From: Michael collins [REDACTED]
Sent: 28 February 2019 10:51
To: Zac Denton; Martyn White; Imogen Locke
Subject: Re: EP/6/19/PL - Request for additional information
Attachments: Screen Shot 2019-02-28 at 10.13.33.png

RE: 8 SEA ROAD, BN16 1JP.
ref: EP/6/19/PL.

DETAIL: GARDEN HOUSE
PROPOSED ROOF PLAN

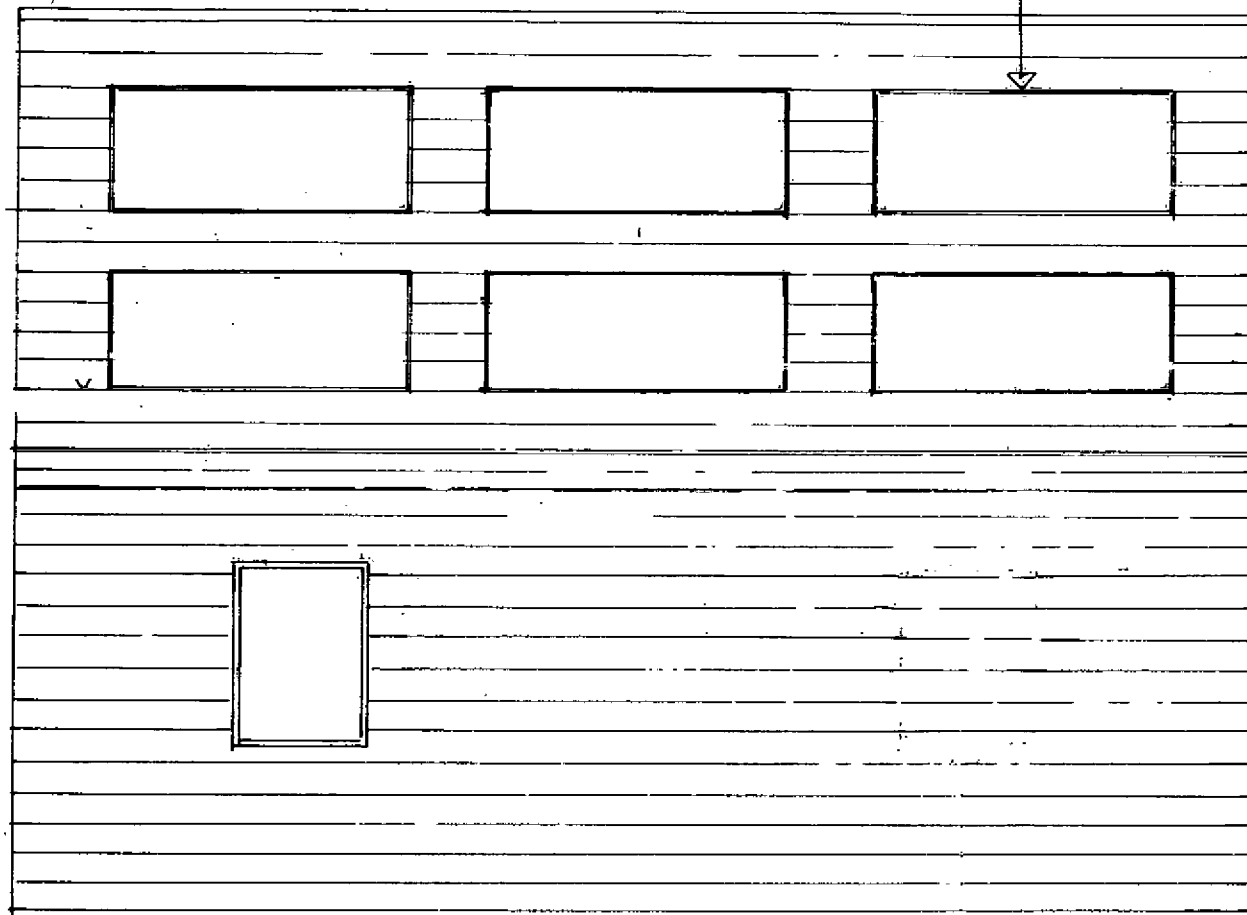
- 2) The proposed solar panels will be partly viewed from the south aspect, however the finish is black & will blend well with the black finish slate roof tiles so shouldn't stand out. The intention is to provide a clean energy supply to both the garden house & cottage.

MCA INTERIORS
30 Ennismore Avenue London, W4 1SF.
Tel: 07768 743629 Email: mcainteriors@hotmail.com
PROJECT: GARDEN HOUSE SEA RD EAST PRESTON SUSSEX BN16 13P
DETAIL: PROPOSED FLOOR PLAN & ELEVATIONS GARDEN HOUSE
SCALE: 1:50
DRWG. NO: 253/01 (15/10/2018)
AMMDS: REV. A: (30/11/2018)

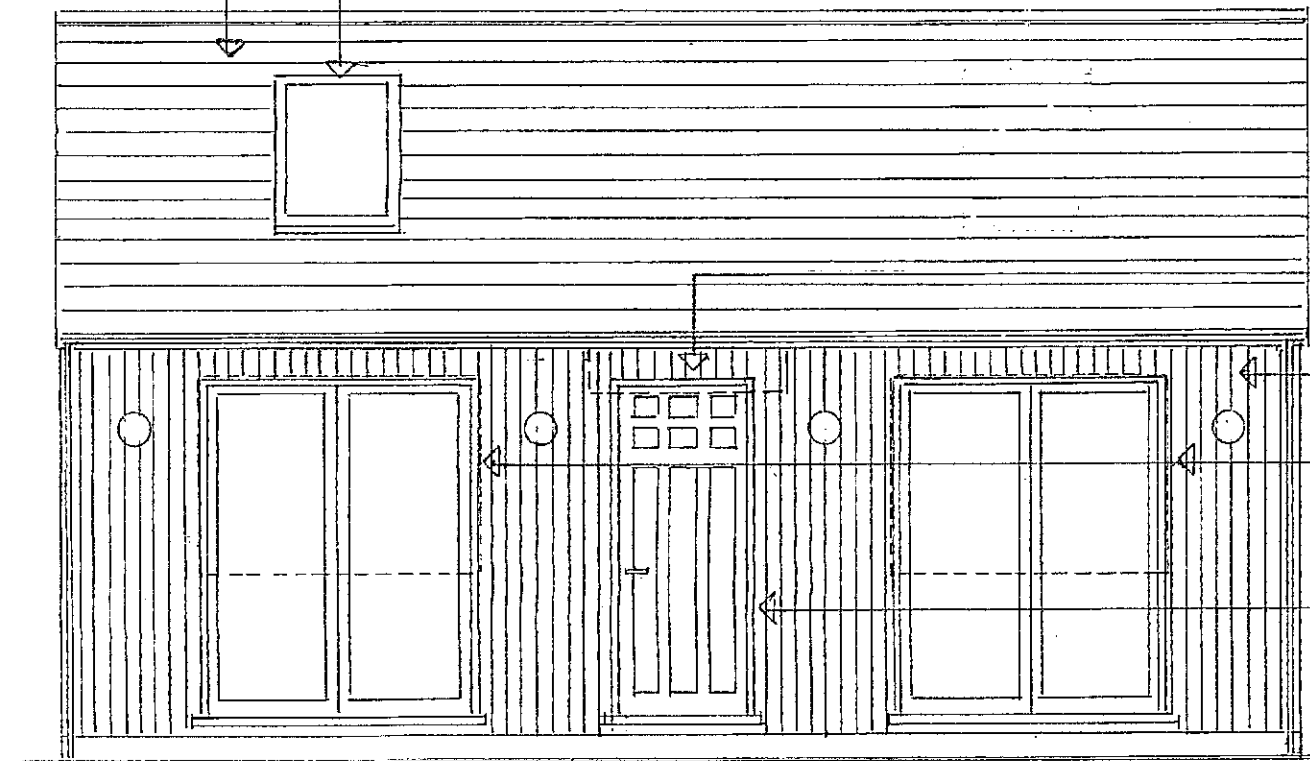
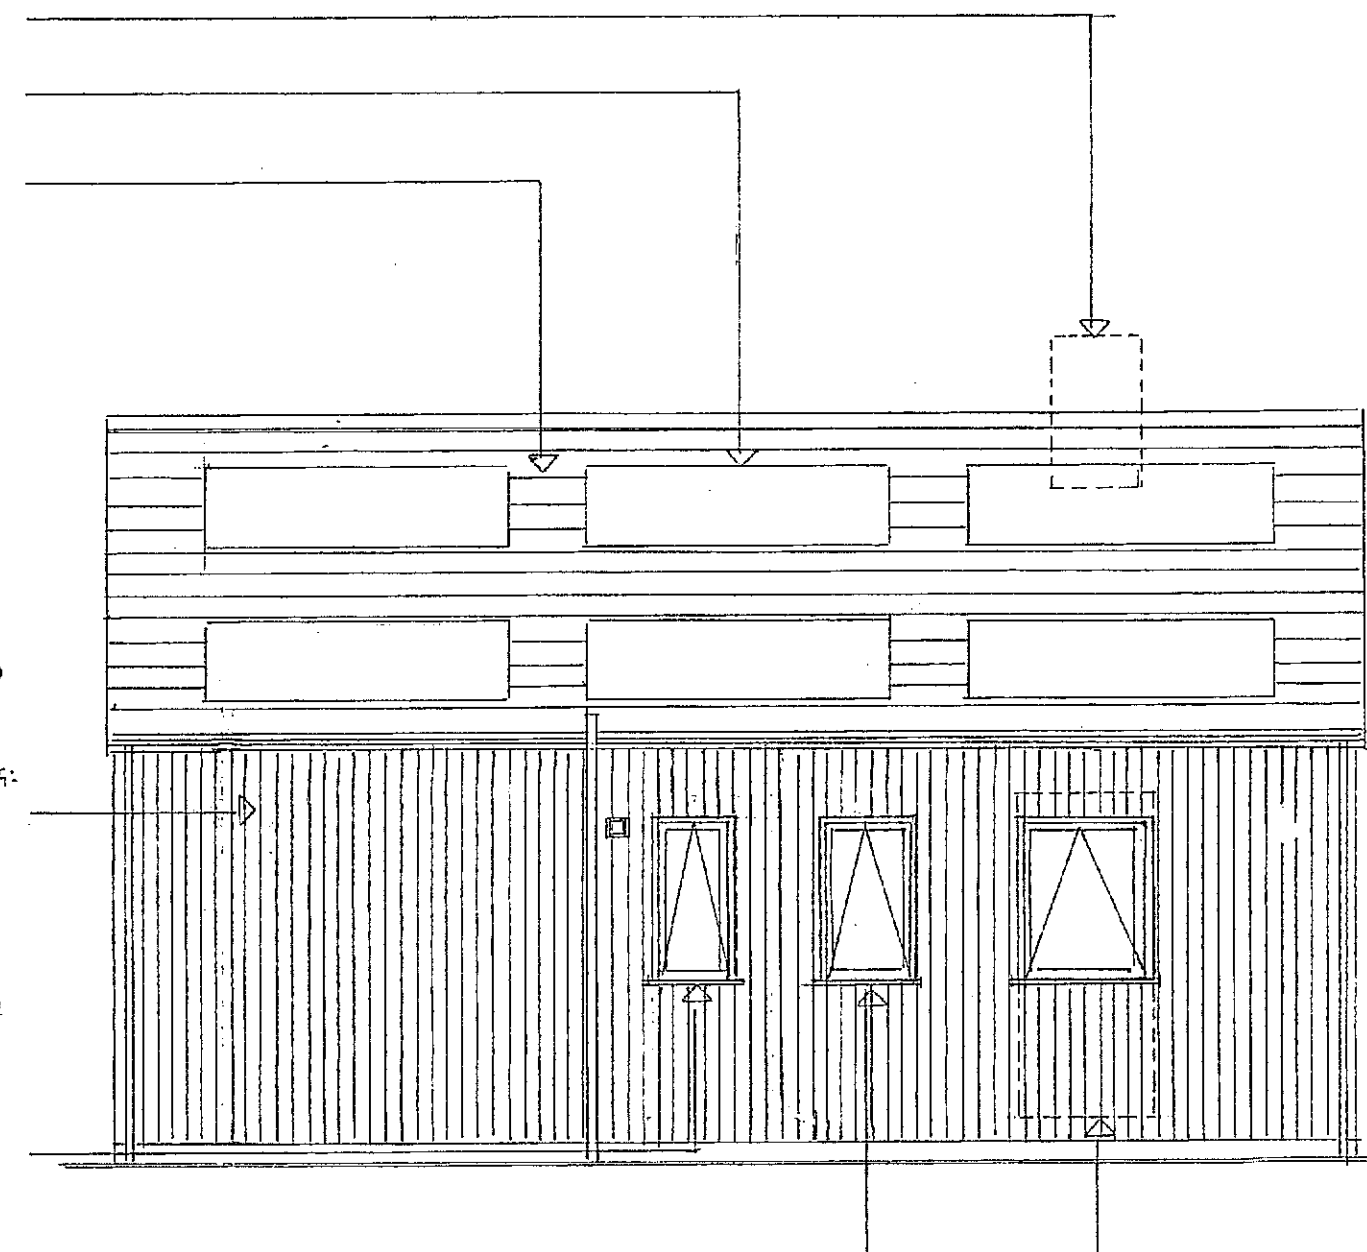
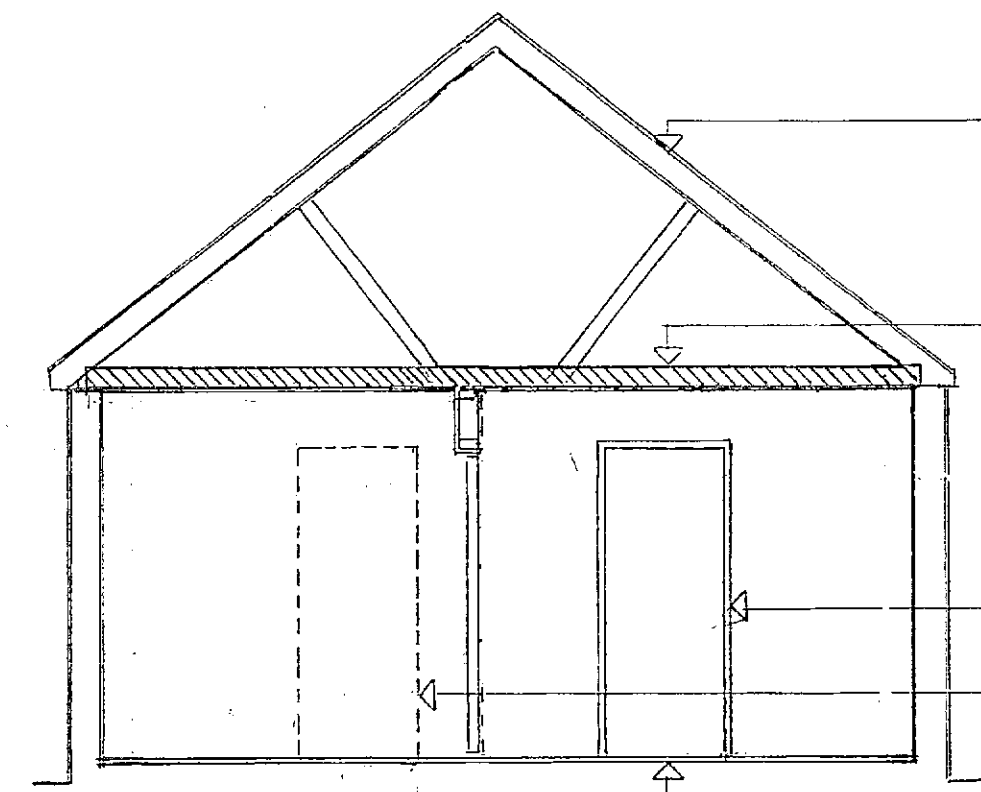
- 1) The Iroko cladding will be untreated & left to weather naturally. It ages well & improves with age. It is used extensively in Canada & Scandinavia as it is hardy.

- 3) The window door spec was not finalised at the time of submission, however this has now been proposed as a dark grey powder coated aluminium framed product by www.slideandfold.co.uk which is highly energy efficient, maintenance free & blends well with the timber cladding. I have attached an image from a recent similar project (although 8 Sea Rd features smaller folding doors within the existing window opening widths to be more commensurate with this building.) I should mention that this combination has been accepted within a world heritage site area. I trust you will agree the combination works well.
